**KIRKLEES METROPOLITAN COUNCIL
INVESTMENT & REGENERATION SERVICE**

Reference No: 2021/62/90890/E

Site Address: Wilman And Son, 1, Market Place, Batley, WF17 5DA

Description: Alterations to convert estate agent to restaurant/cafe
(Class E) (Listed Building within a Conservation Area)

PROJECT:	DESCRIPTION:	TITLE:	DRAWING REF:	REV:
1 MARKET PLACE, BATLEY, WF17 5DA	CHANGE OF USE FROM A2 TO A5	EXISTING AND PROPOSED	20163-D03-B	
		DRWN BY: HED	DATE: 27/02/21

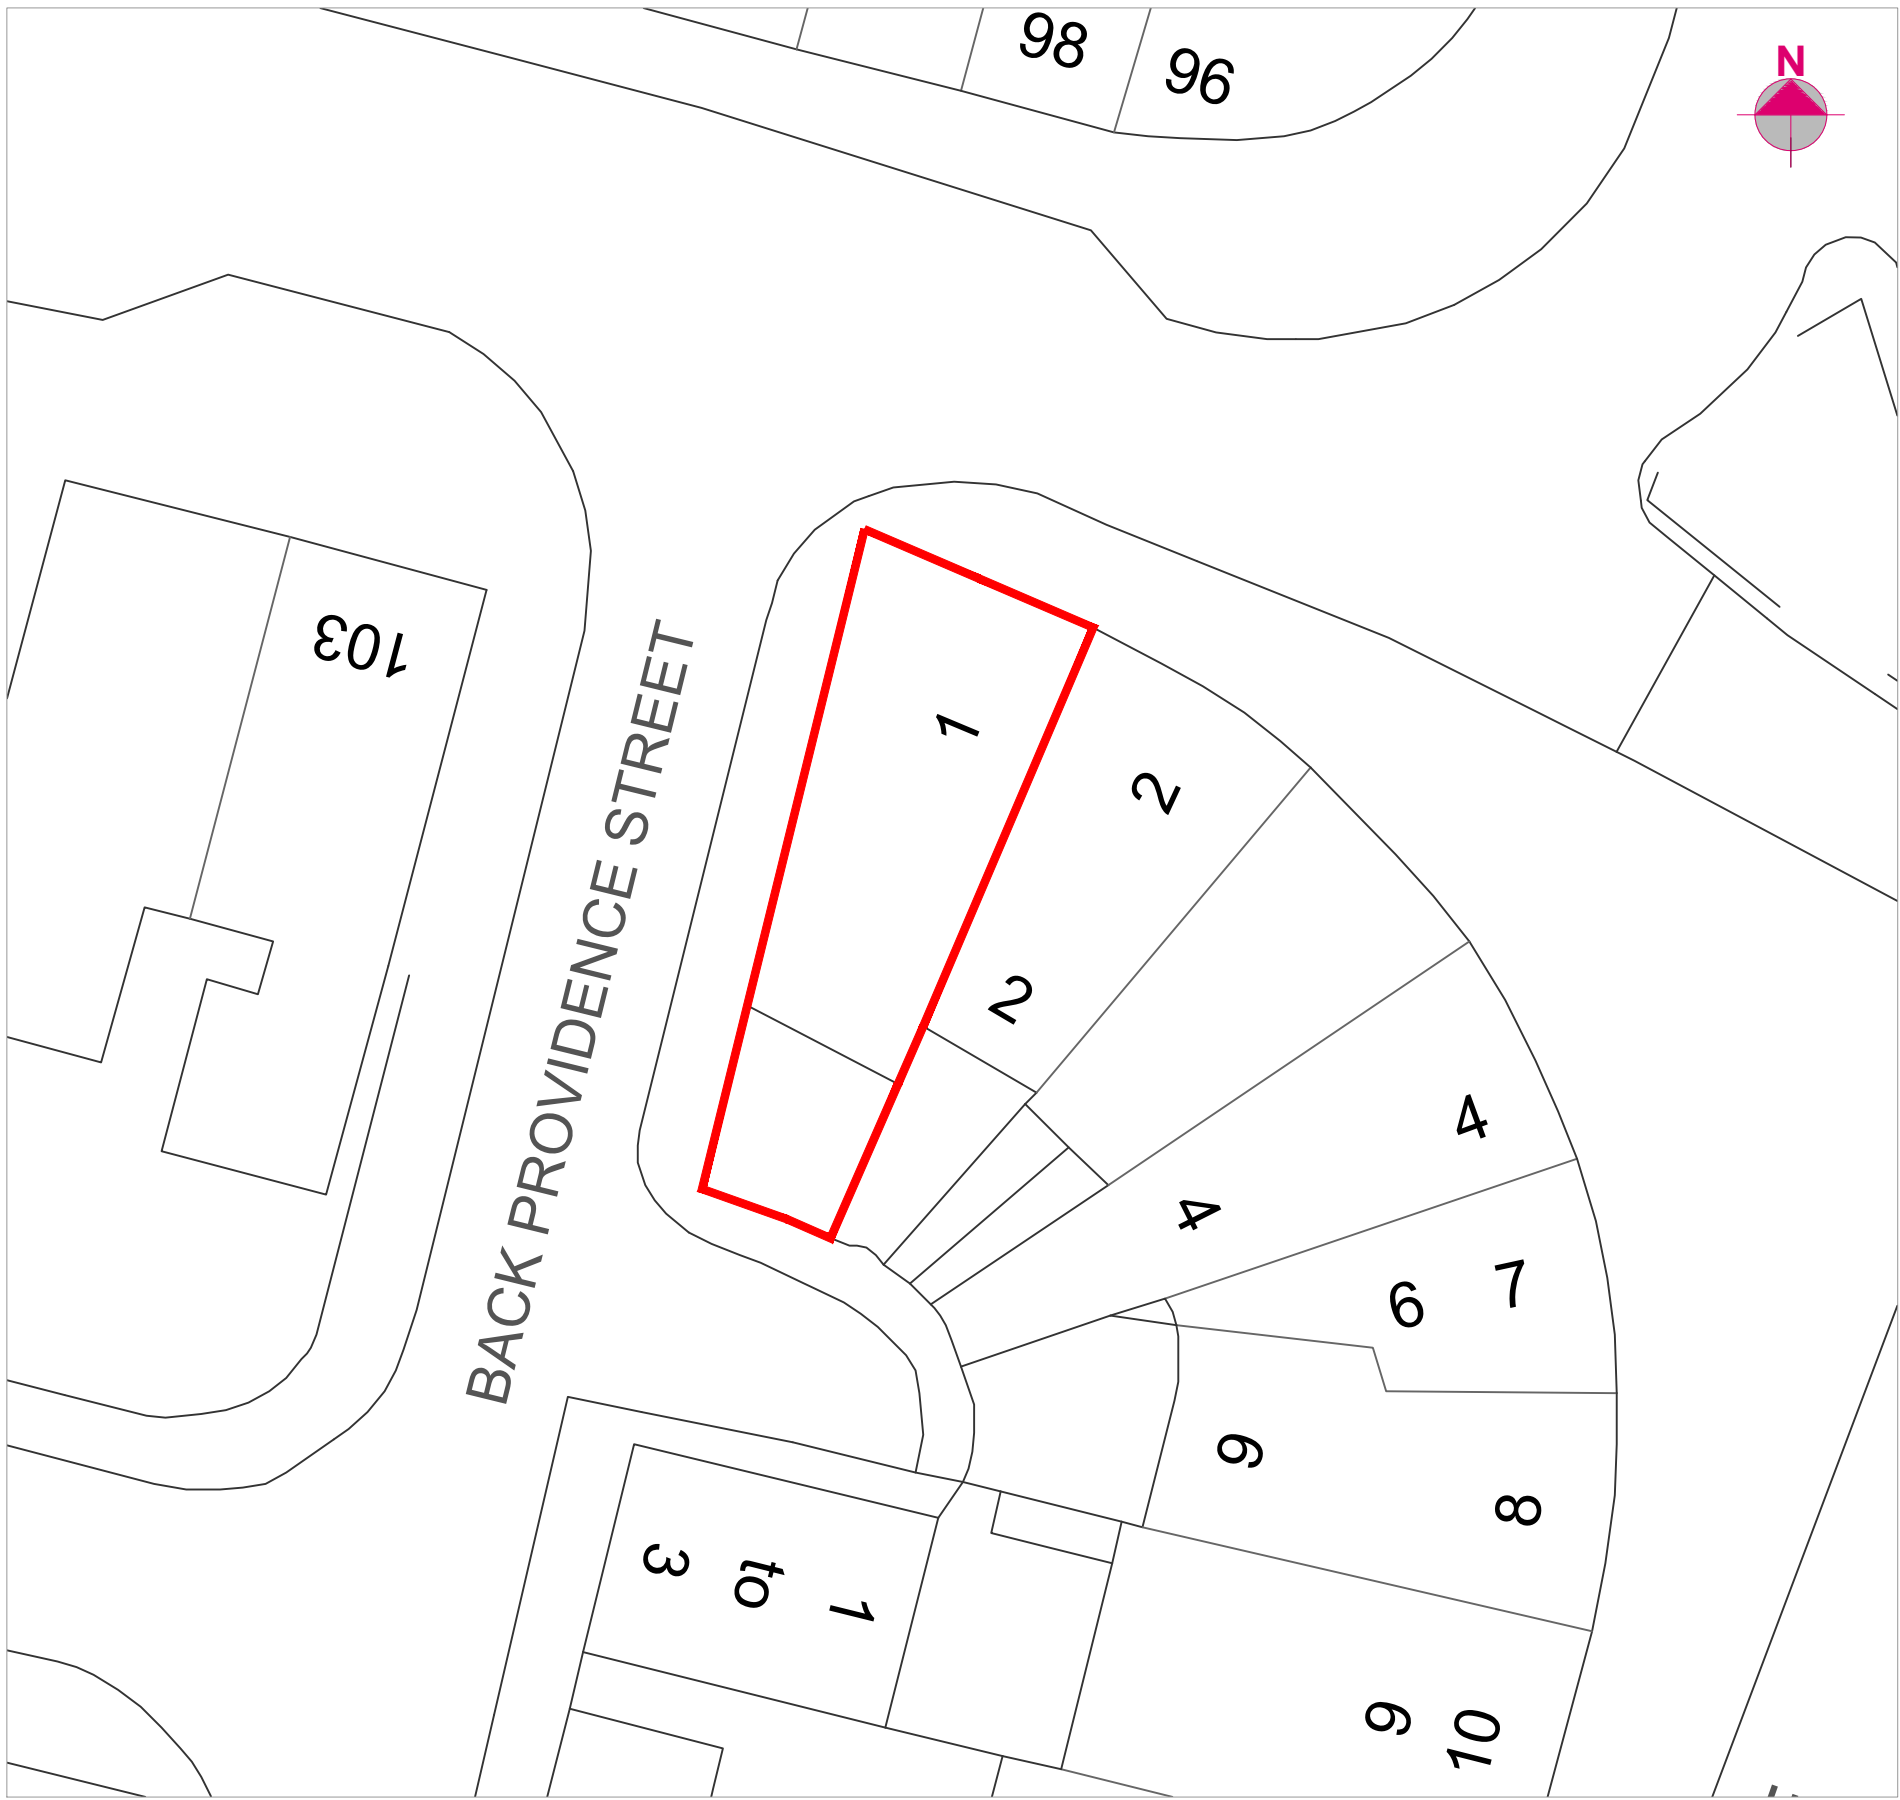
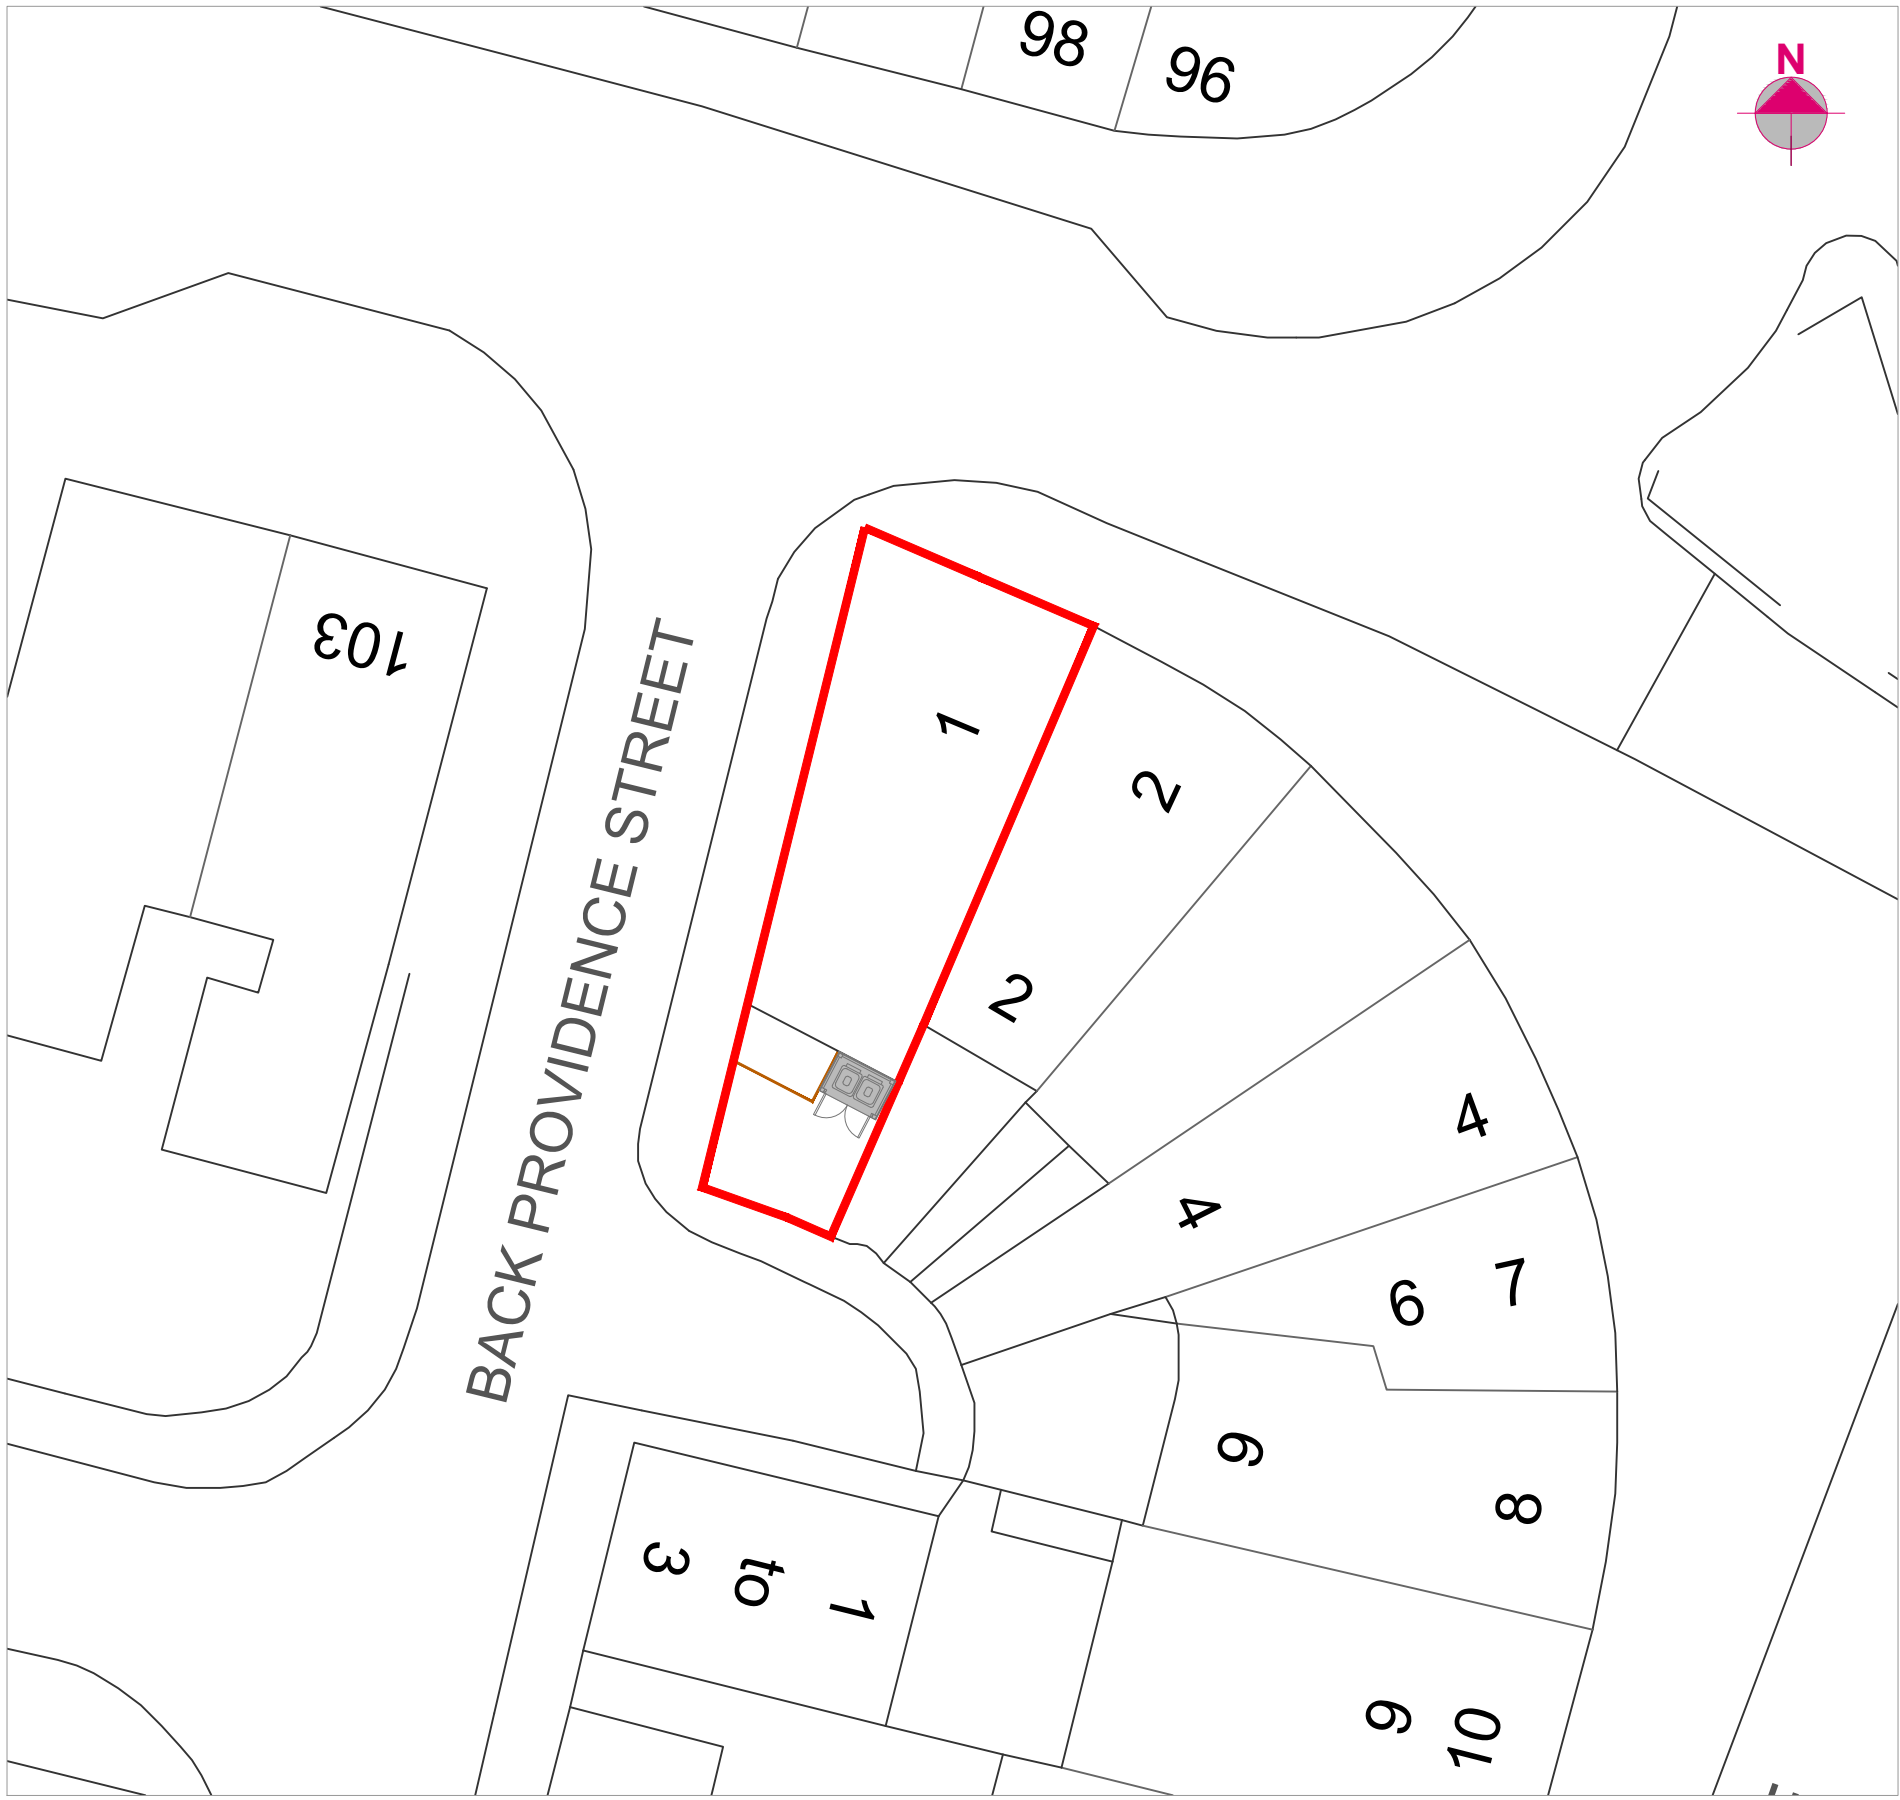
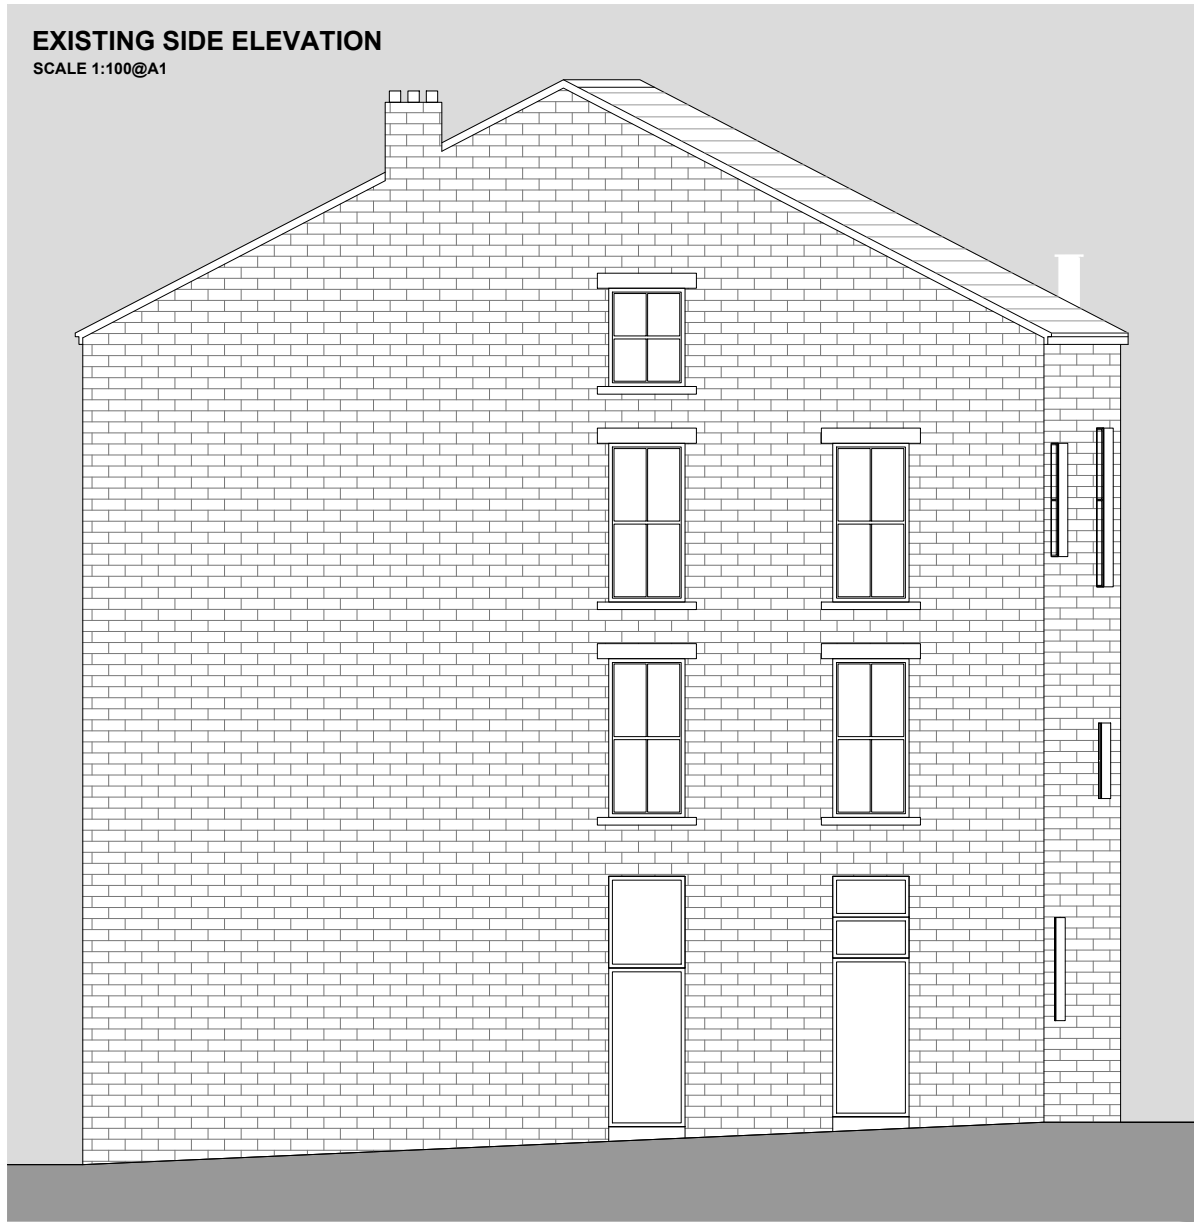
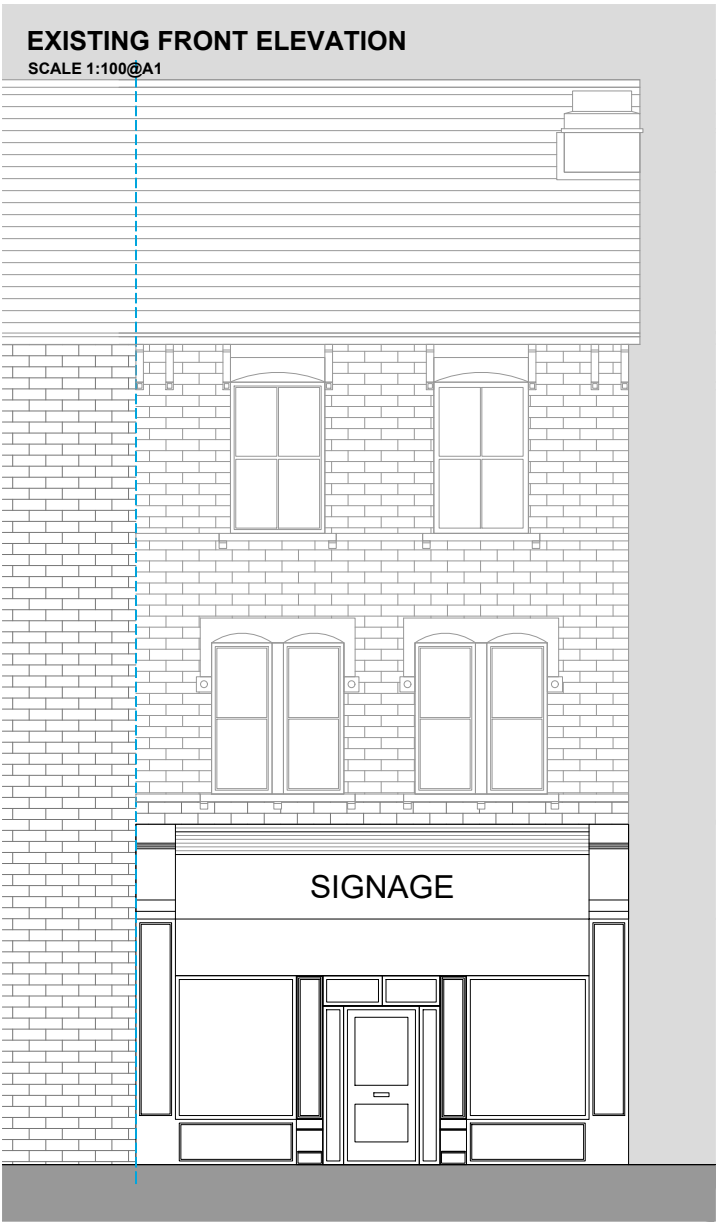
By virtue of part of the application being a change of use, this itself will not materially adversely impact upon the listed building or the Conservation Area. The alterations to the interior and exterior of the building, including stripping out finishes and altering the shop front, are minimal and include the removal of later partitions and minor alterations to areas of low significance and are, therefore, acceptable. The repair of the existing timber shop front is supported, as this will improve the facade, with signage illuminated by grey swan neck light fittings fixed to the timber shop front and not into the masonry.

The rear elevation is only visible from Back Providence Street and has relatively low significance, therefore the proposed interventions to the rear elevation are acceptable. The harm caused by the installation of a flue is mitigated by finishing it in black and fixing it to the rear elevation, and the public benefit of repairing and refurbishing the shop front and bringing this vacant building into use is considered to outweigh this slight harm.

Subject to a condition requiring all flue brackets to be fixed into mortar joints and not into the masonry, the principle of development to a listed building in the Conservation Area is considered acceptable, as the proposal complies with policies LP24 and LP35 of the KLP and Chapter 16 of the NPPF.

7. Notwithstanding the plans hereby approved, all flue brackets shall be fixed into mortar joints and not into the masonry on the building.
